**KIRKLEES METROPOLITAN COUNCIL  
DEVELOPMENT & MASTER PLANNING SERVICE**

**DELEGATED DECISION FOR PRIOR APPROVAL FOR CHANGE OF USE  
FROM COMMERCIAL, BUSINESS AND SERVICE USES TO  
DWELLINGHOUSES**

**Reference no. 2023/CL/92836/W**

**Site Address 1st & 2nd floors, 9-13, Market Walk,  
Huddersfield, HD1 2QA**

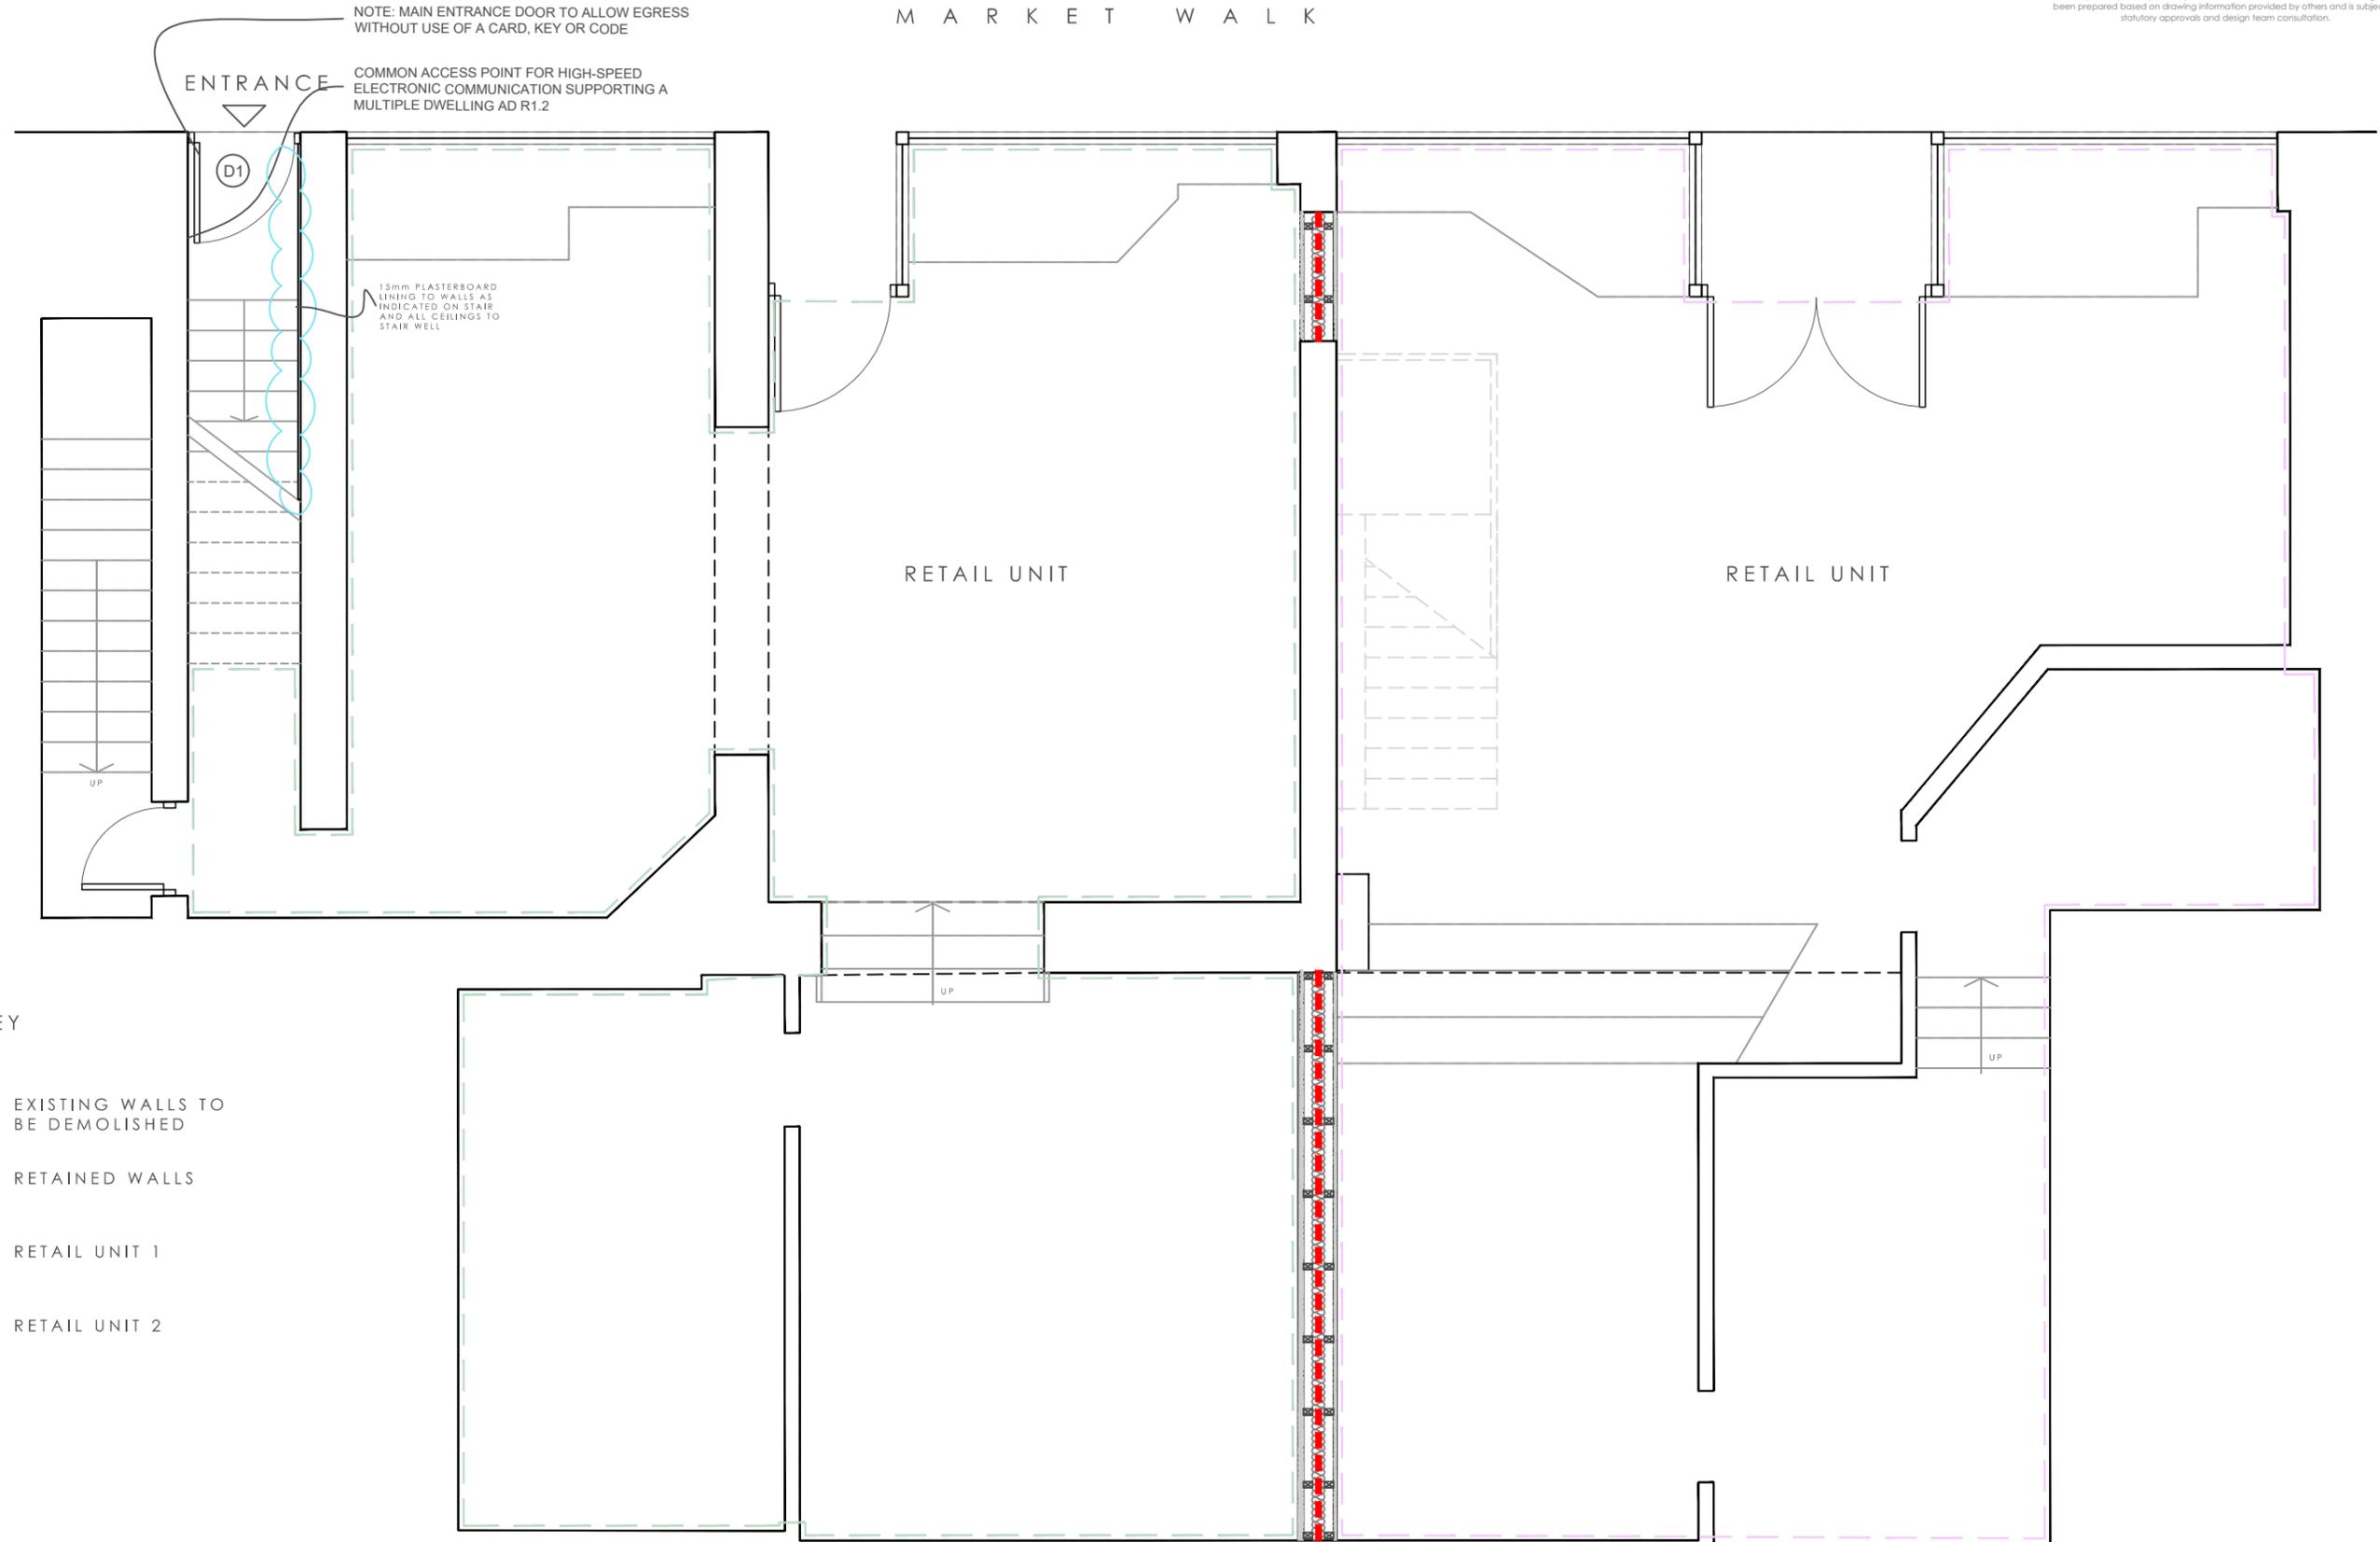
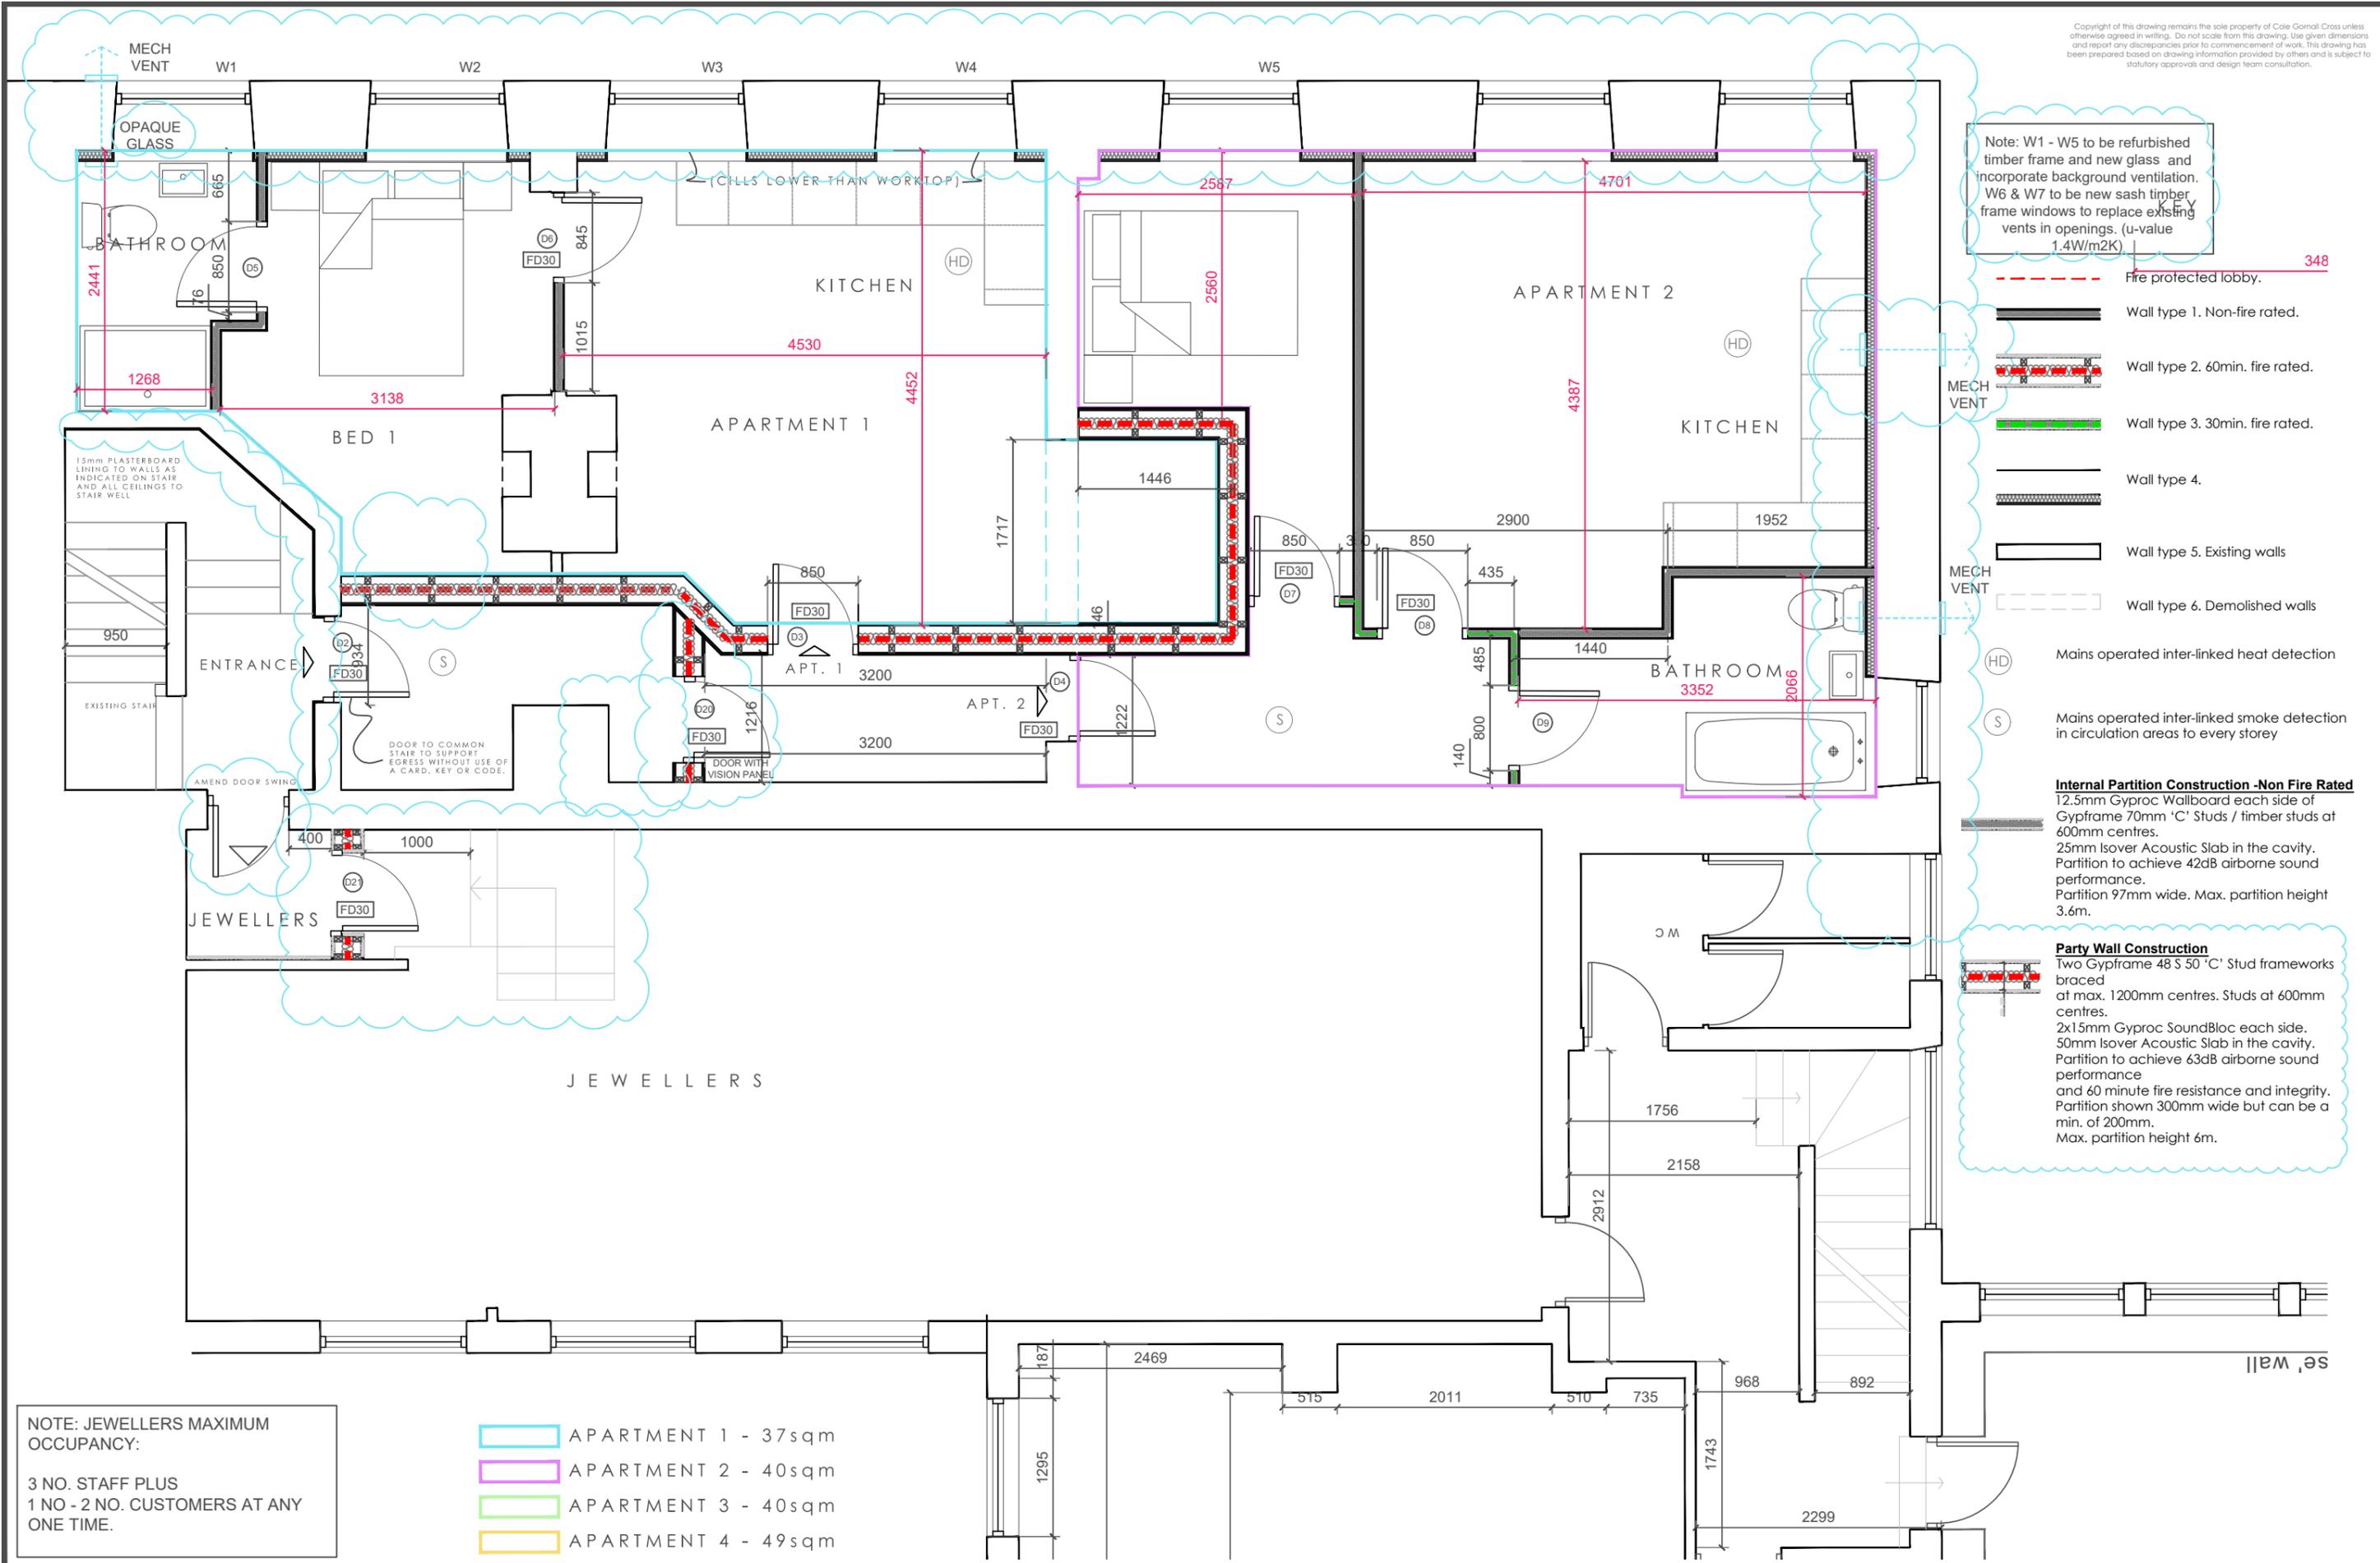
Apartment 1 is proposed to be a one bedroom first floor flat. The Technical Housing Standards document states that a one-bedroom flat for one person (minimum assessed) one storey should be at least 37 or 39 square metres dependant on whether the bathroom has a shower. In this instance, the internal accommodation is proposed to approximately 30.7 square metres which would not accord with the recommended space standards. However, the bedroom is shown to sleep two persons which requires 50 square metres of space, thus contrary to space standards.

Apartment 2 is proposed to be a one bedroom first floor flat. The Technical Housing Standards document states that a one-bedroom flat for one person (minimum assessed) one storey should be at least 37 or 39 square metres dependant on whether the bathroom has a shower. In this instance, the internal accommodation is proposed to approximately 34.6 square metres which would not accord with the recommended space standards. However, the bedroom is shown to sleep two persons which requires 50 square metres of space, thus contrary to space standards.
